ASSESSMENT REPORT

47-50 The Esplanade, Ettalong Beach
MP 09_0121 MOD 4

This report is an assessment of a request to modify Project Approval 09_0121 for a mixed-use development at Ettalong Beach, in the Central Coast local government area.

The request has been lodged by Planning Lab, on behalf of Longbeach Living Pty Ltd (the Proponent), pursuant to section 4.55(1A) of the *Environmental Planning and Assessment Act 1979* (EP&A Act). The proposal seeks approval to modify the approved non-trafficable roof area.

FLOOR PLAN (COMPARISON SHEET)

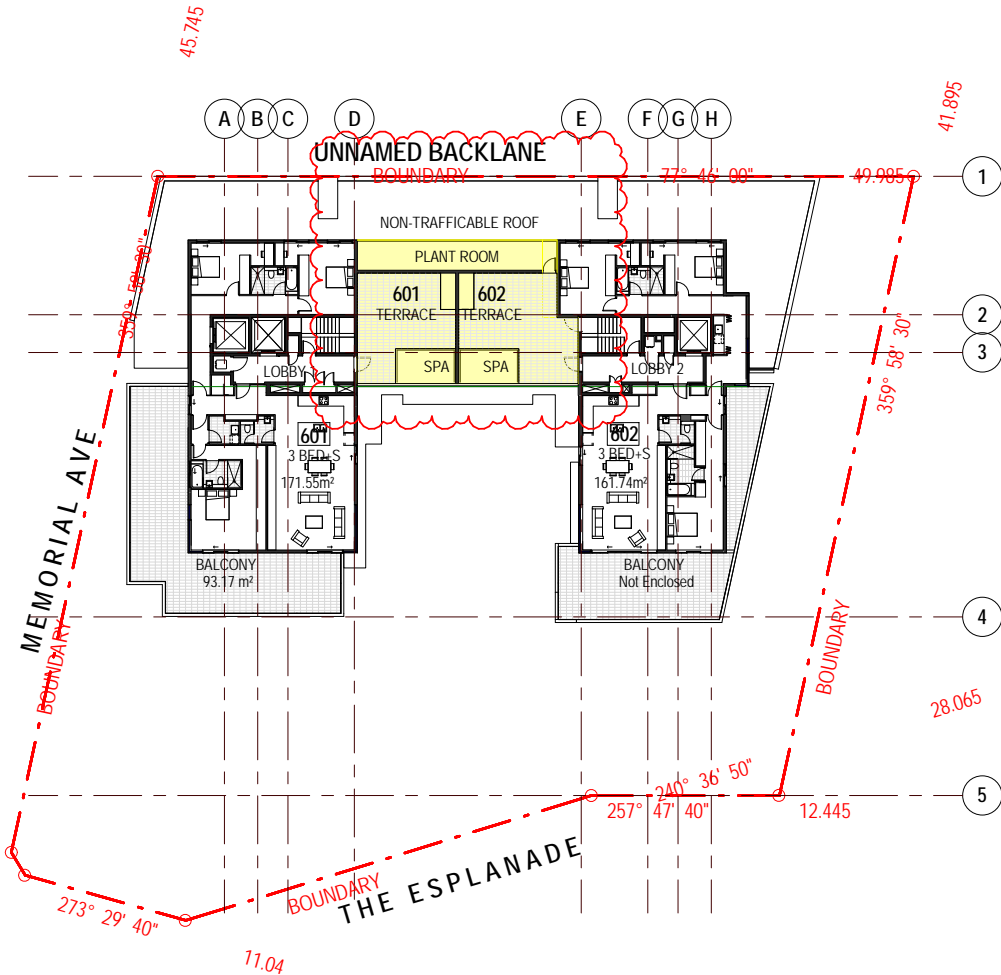
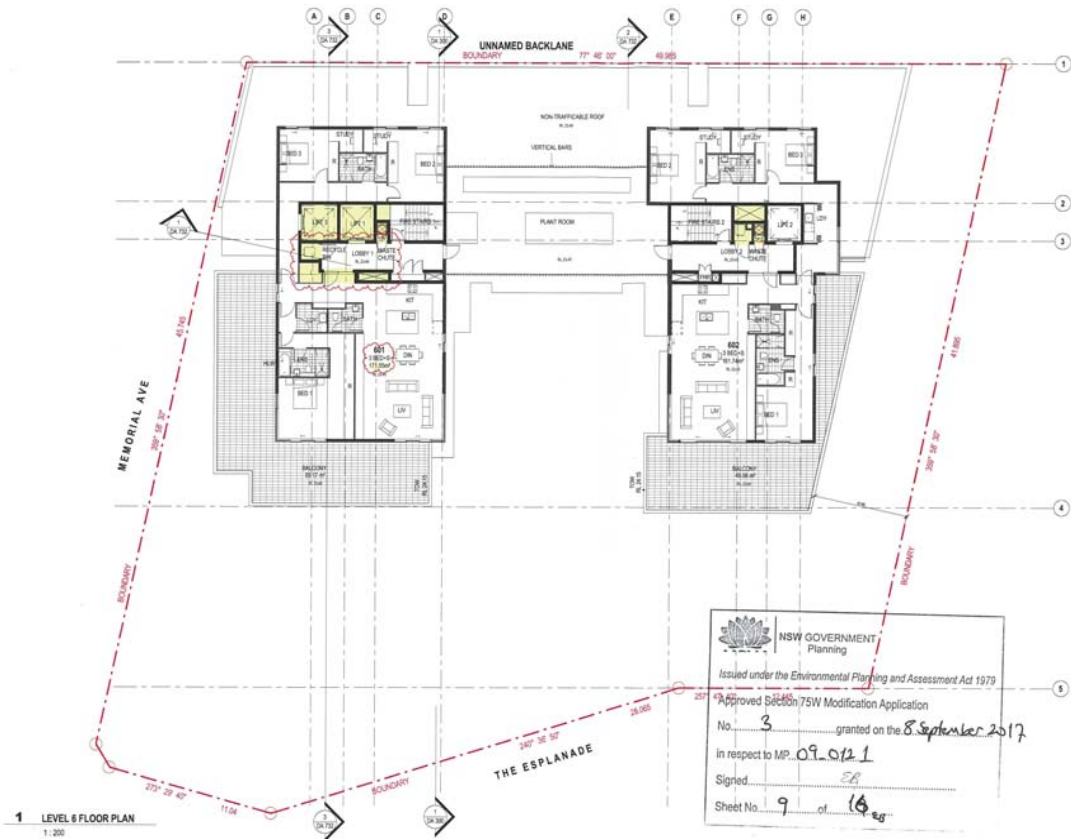
- potential amenity impacts between units 601 and 602 would be appropriately mitigated through the construction of the 2.95m masonry wall, separating the two terraces;

- the potential noise impacts associated with the relocation of the plant room will be mitigated through the use of double skin brick wall with a lined cavity, meeting the BCA requirements for noise between a plant room and bedroom space.

Drawing Title
NORTH & SOUTH
ELEVATIONS (COMPARISON SHEET)

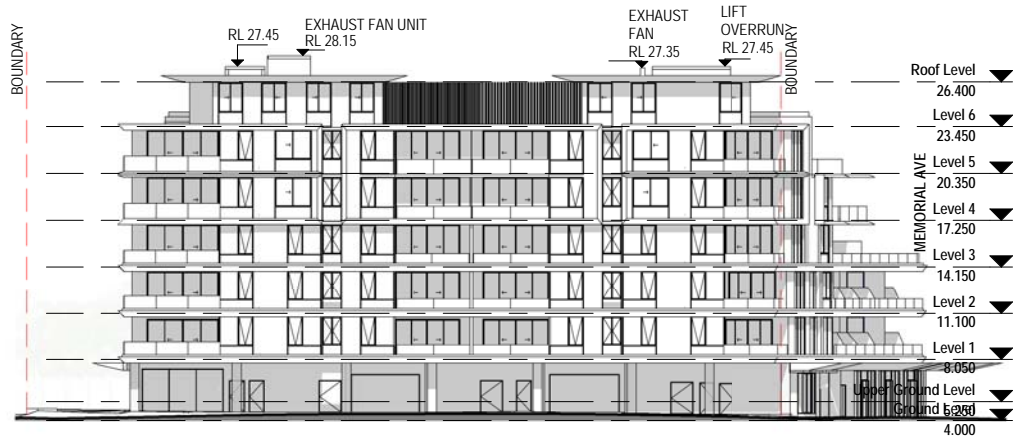
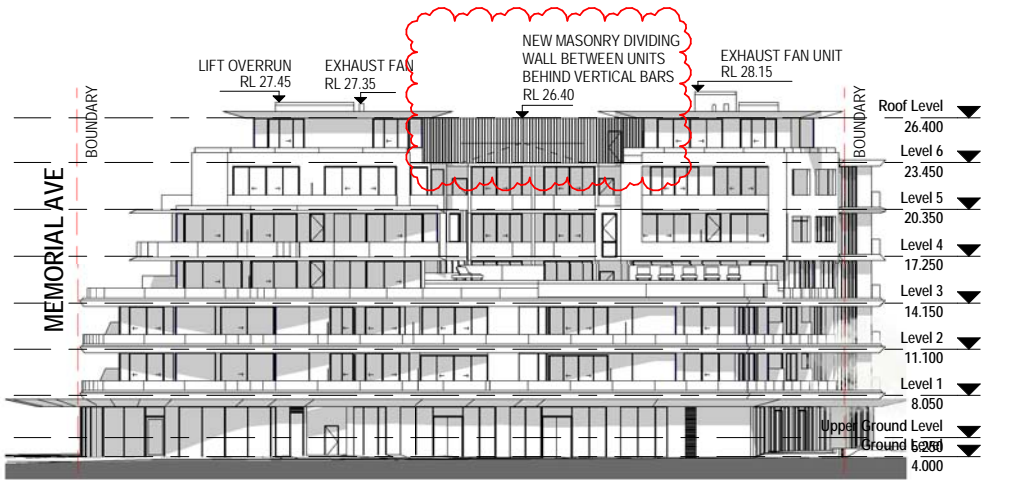
- impacts on surrounding properties;
- the potential visual impacts associated with the proposal would be mitigated by maintaining the previously approved vertical bars screening the proposed terraces and plant room. As shown in **Figure 3 and 4** the relocation of the plant room will not substantially alter the buildings appearance;

- potential overlooking from the proposed terraces towards other surrounding units would be appropriately mitigated by the retention of the previously approved screening (**Figure 4**) along the full frontage of the terraces;
